**Town and Country Planning Act 1990
Application for Permission to Develop Land**

Response from Pollution & Noise Control

PNC Reference No:	WK/201710047
Name of Planning Officer dealing with the matter:	DC.Admin@kirklees.gov.uk
Application Number:	2017/91095
Proposed Development:	Discharge condition 3 (ventilation) on previous permission 2014/90017 for change of use and alterations to convert outbuildings into restaurant (within a Conservation Area)
Location:	The Watermill, 24 Station Road, Slaithwaite, Huddersfield, HD7 5AW
Date Required By Planning:	31st May 2017

East Elevation

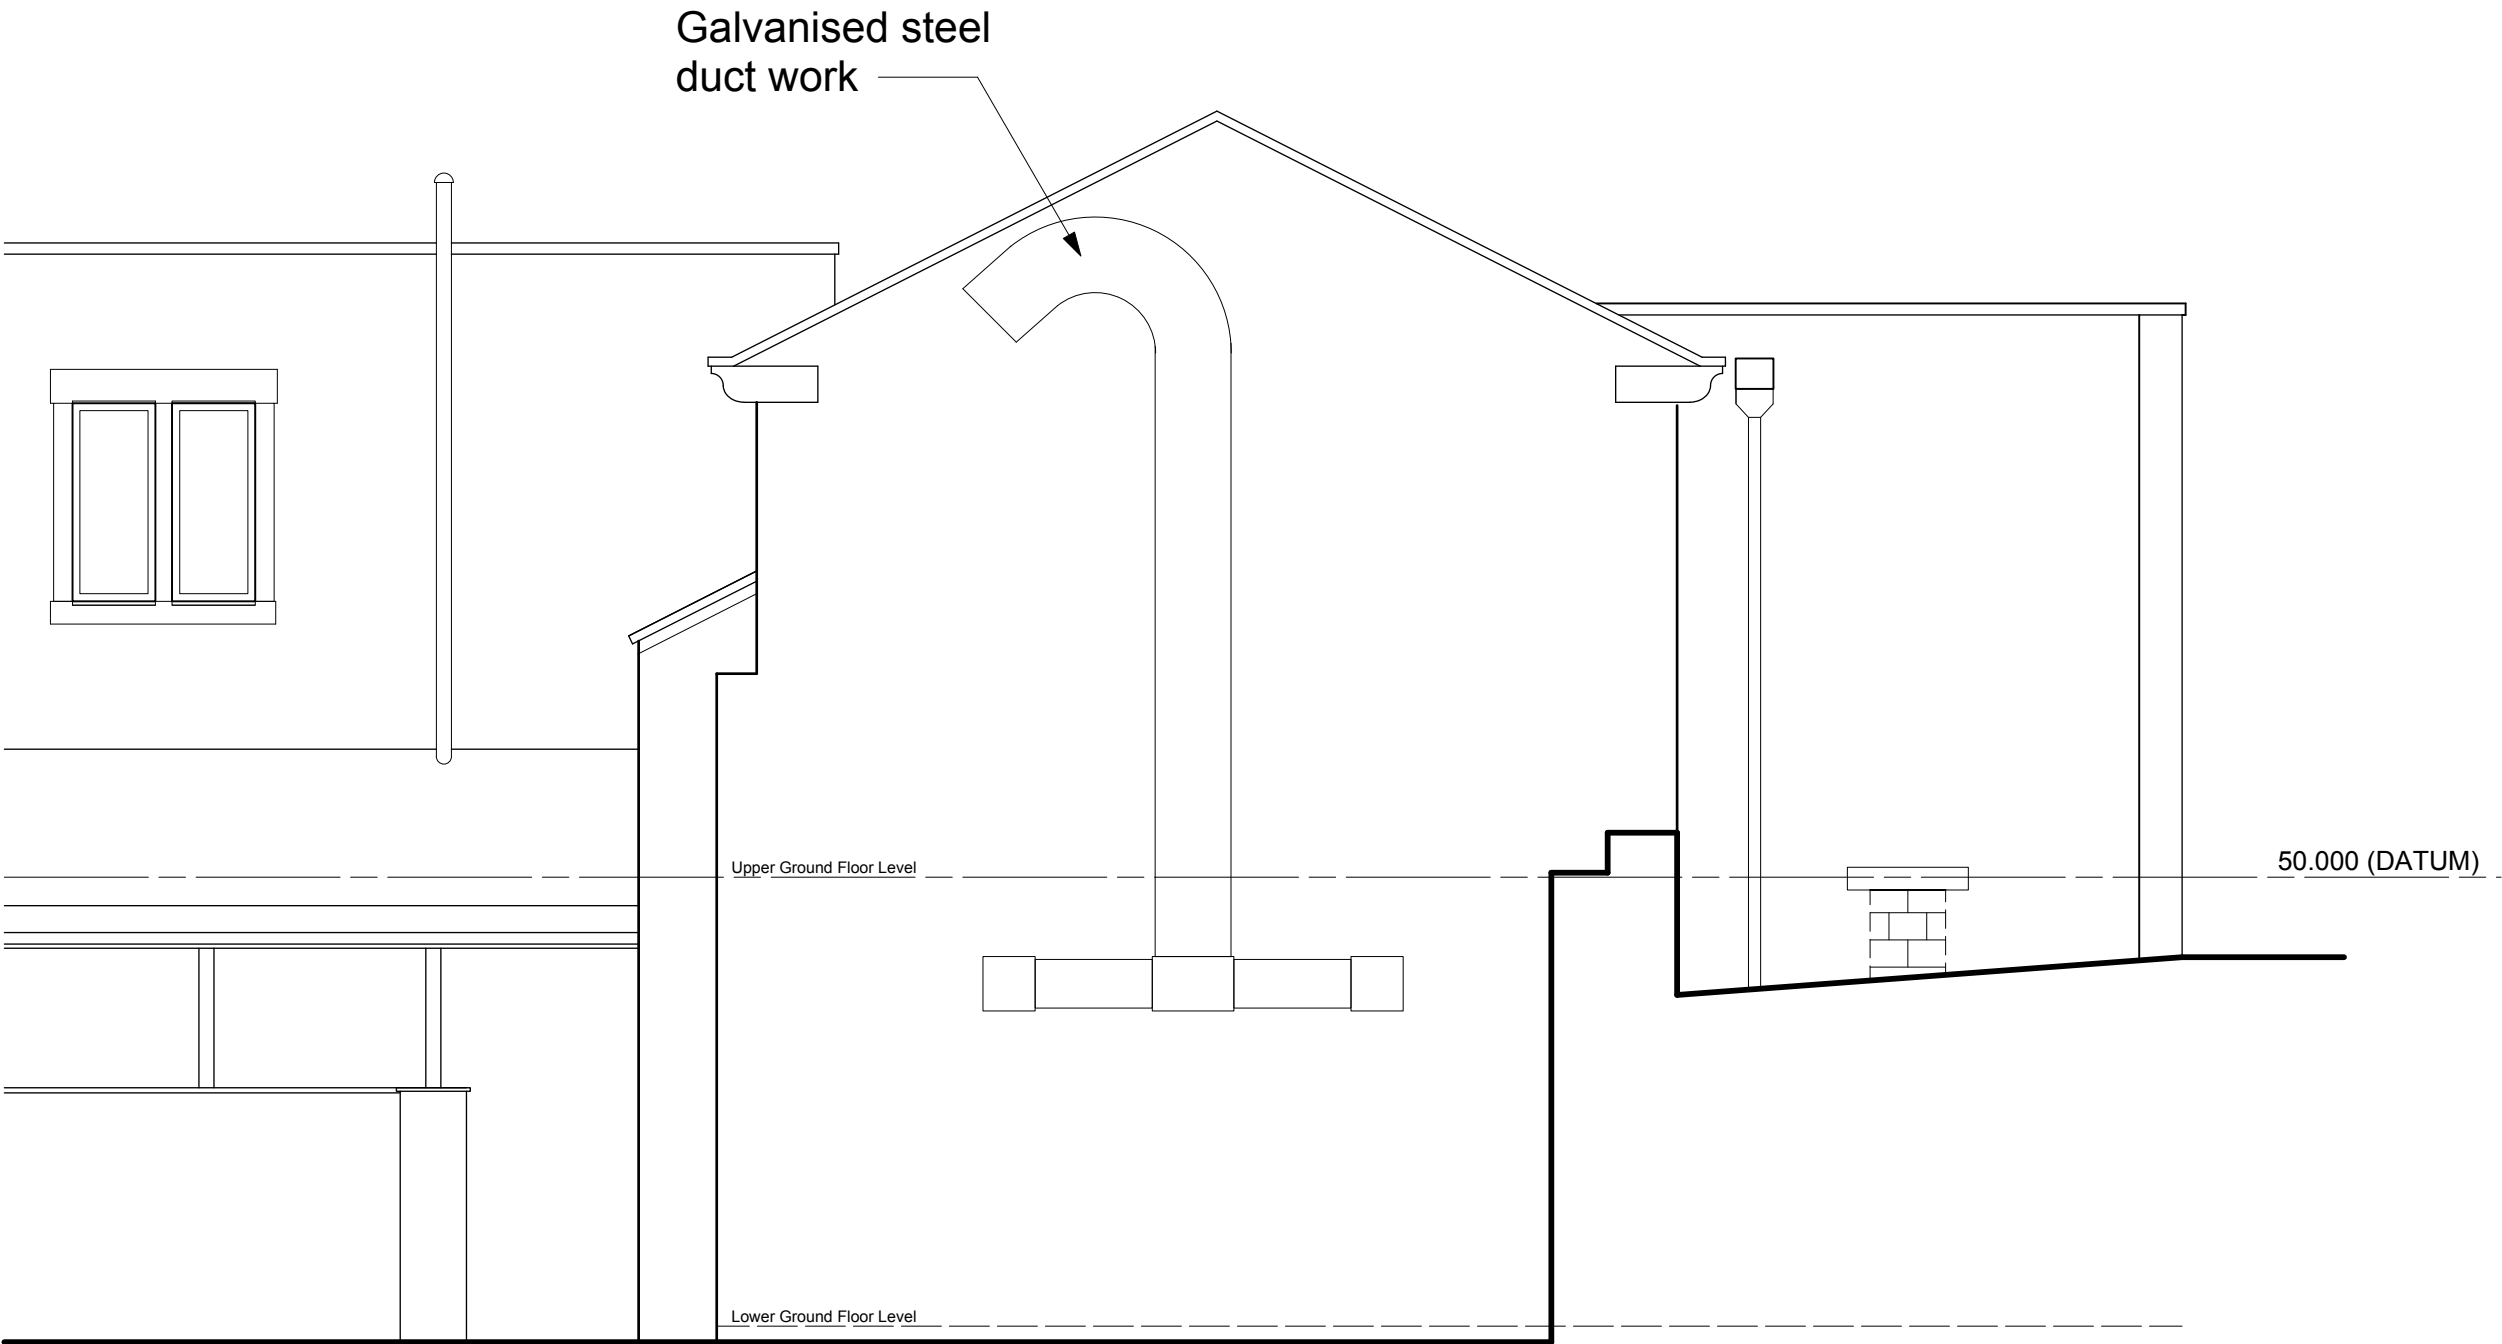
COMMENTS			
I have reviewed the information submitted to discharge Condition 3. I am concerned that the applicant specifically states that there is no odour control included in the system and as such there is likely to be cooking odours being emitted. I am also concerned that the flue terminates with a bend which will push any emissions back down to ground level rather than directing straight up to aid dispersion. The data sheet for the fan specifies noise levels but does not indicate the distance from the fan that these levels have been measured. Therefore I am not satisfied that the proposed ventilation system will minimise disturbance to nearby residents from both odour and noise and as such I am not in a position to recommend the discharge of Condition 3 of the previous permission 2014/90017.			
Date:	16 May 2017	Officer:	Alexandra Garry Ext 70832
